From: Victor Levy [REDACTED]
Sent: 01 October 2014 13:13
To: Simon Davis
Cc: 'Des Dunlop' [REDACTED]
Subject: Revised Site Plan Bognor

We have revised the site plan to remove the fencing and hard standing at the rear.
McDonalds have a fence on the North boundary.

Site Plan as Proposed

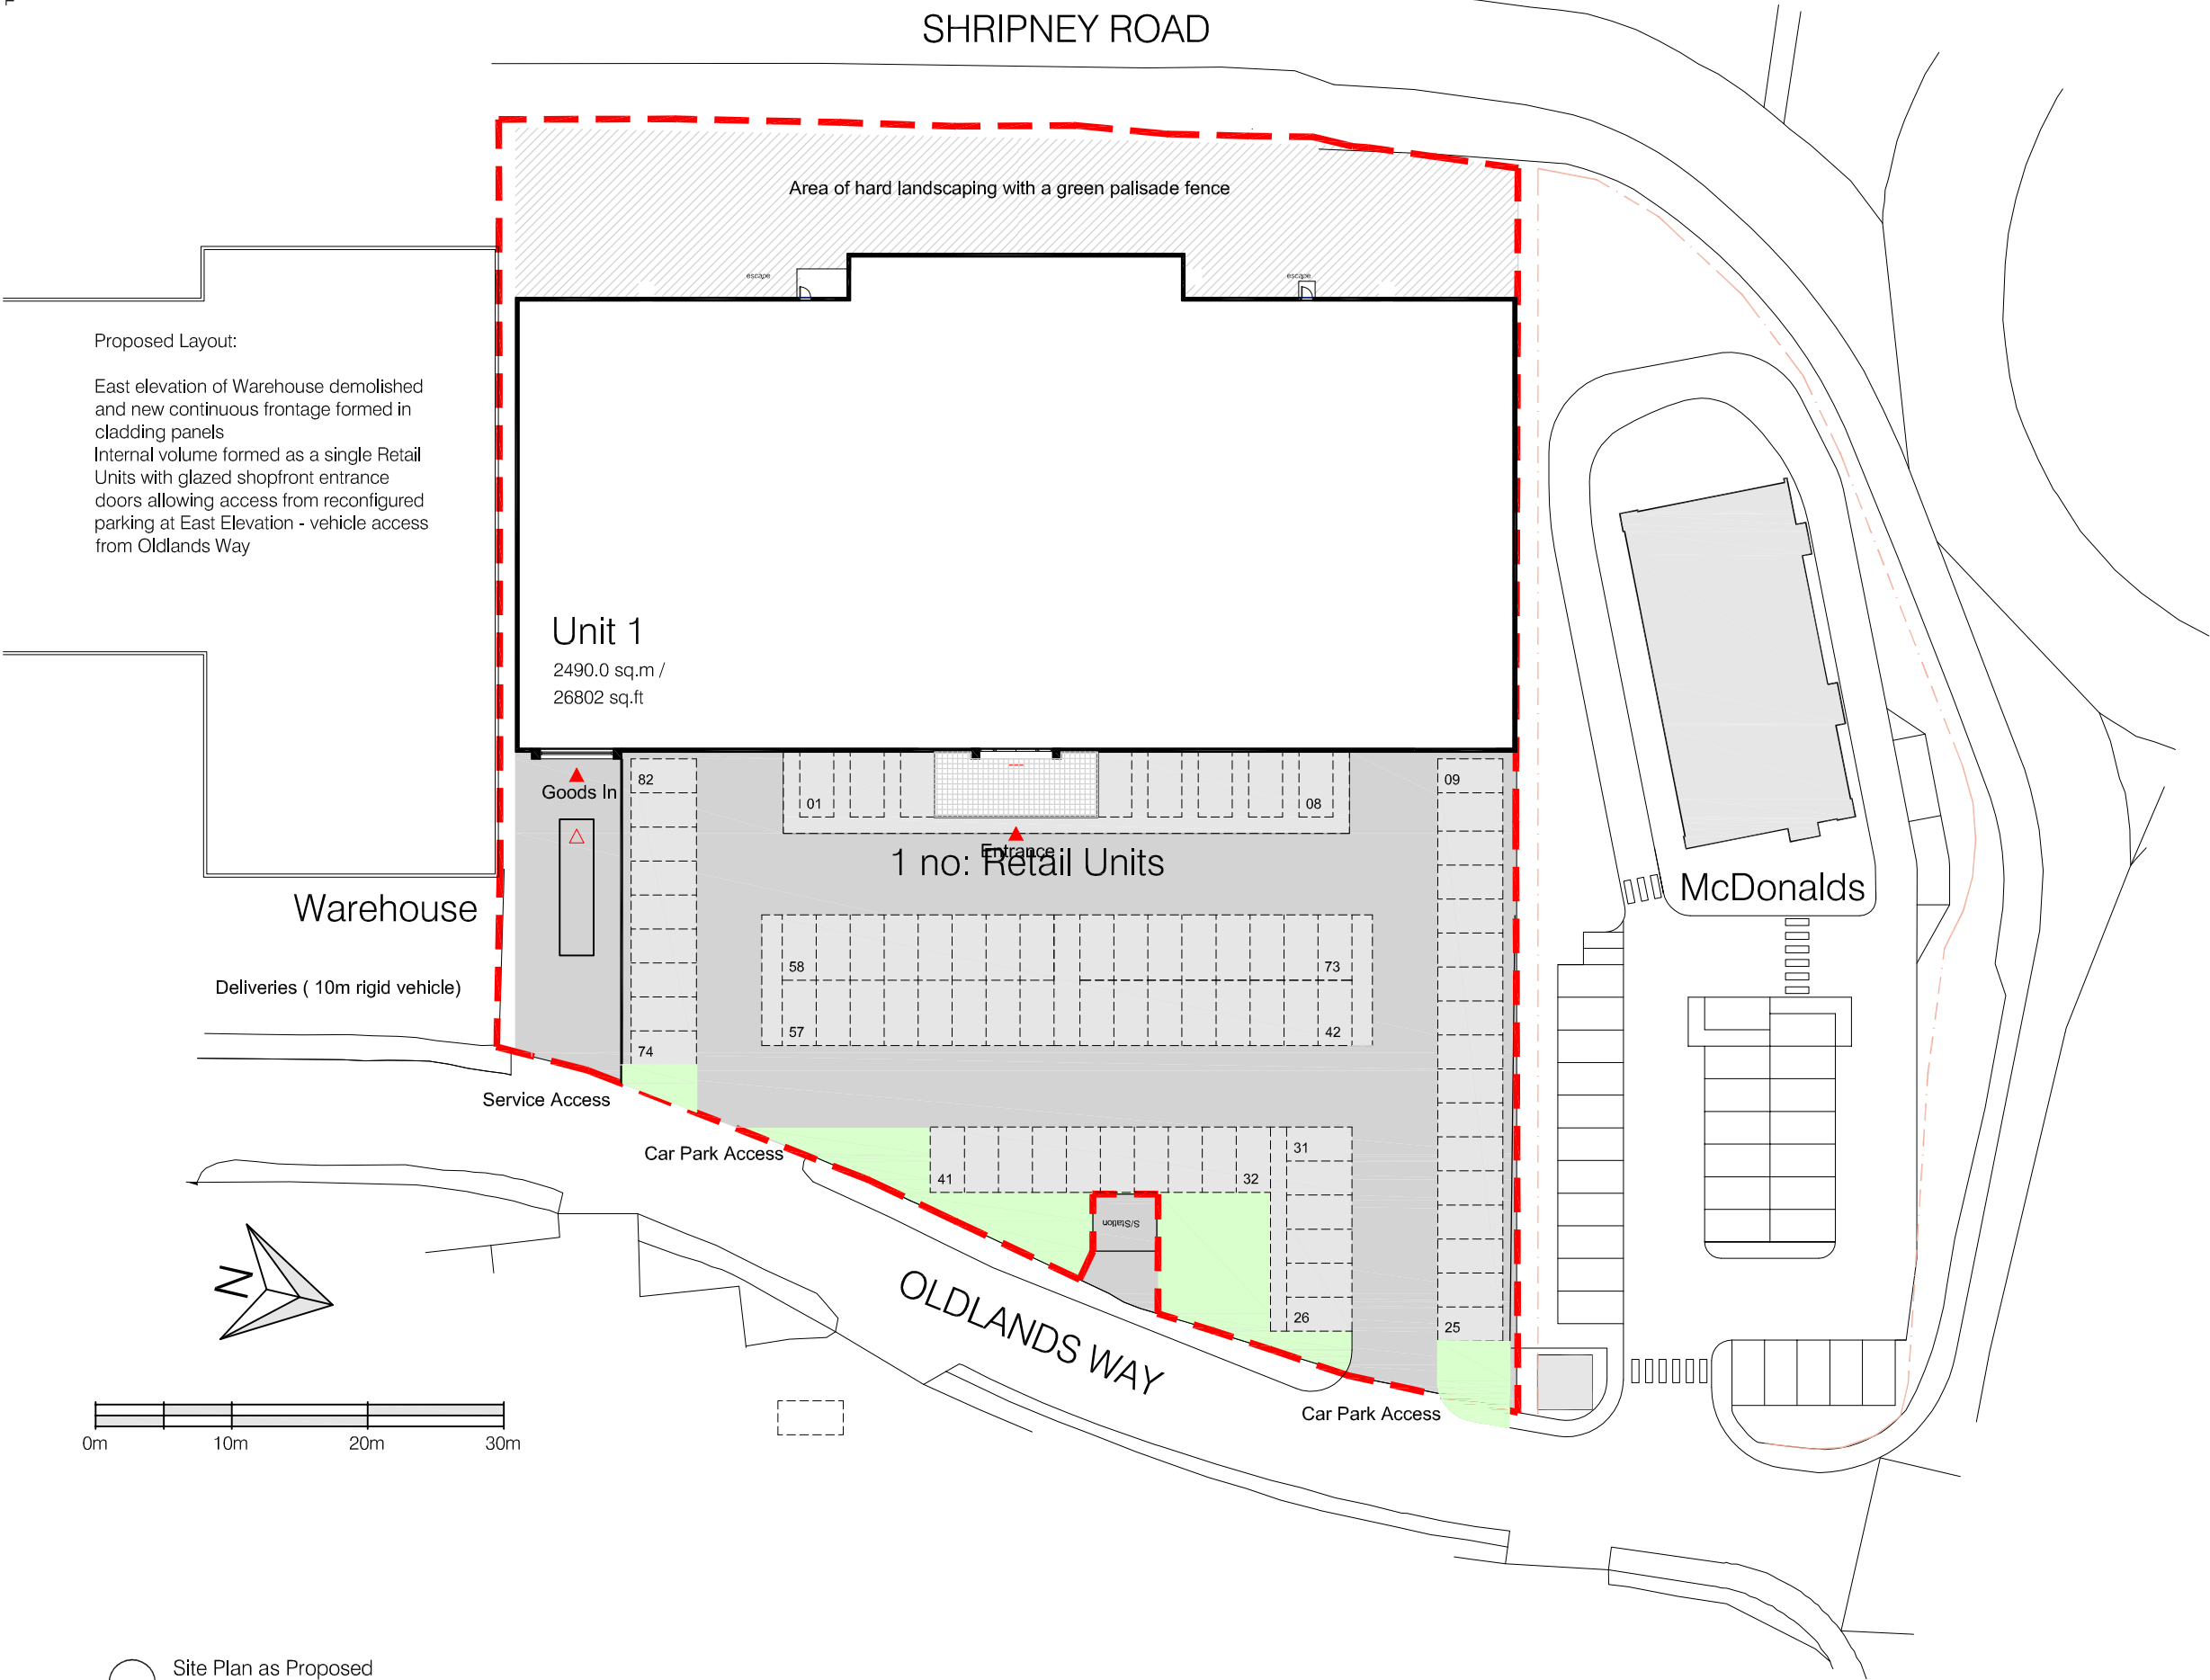
We have left a short fence on the front South boundary only.
Des is finalising the retail condition(s).
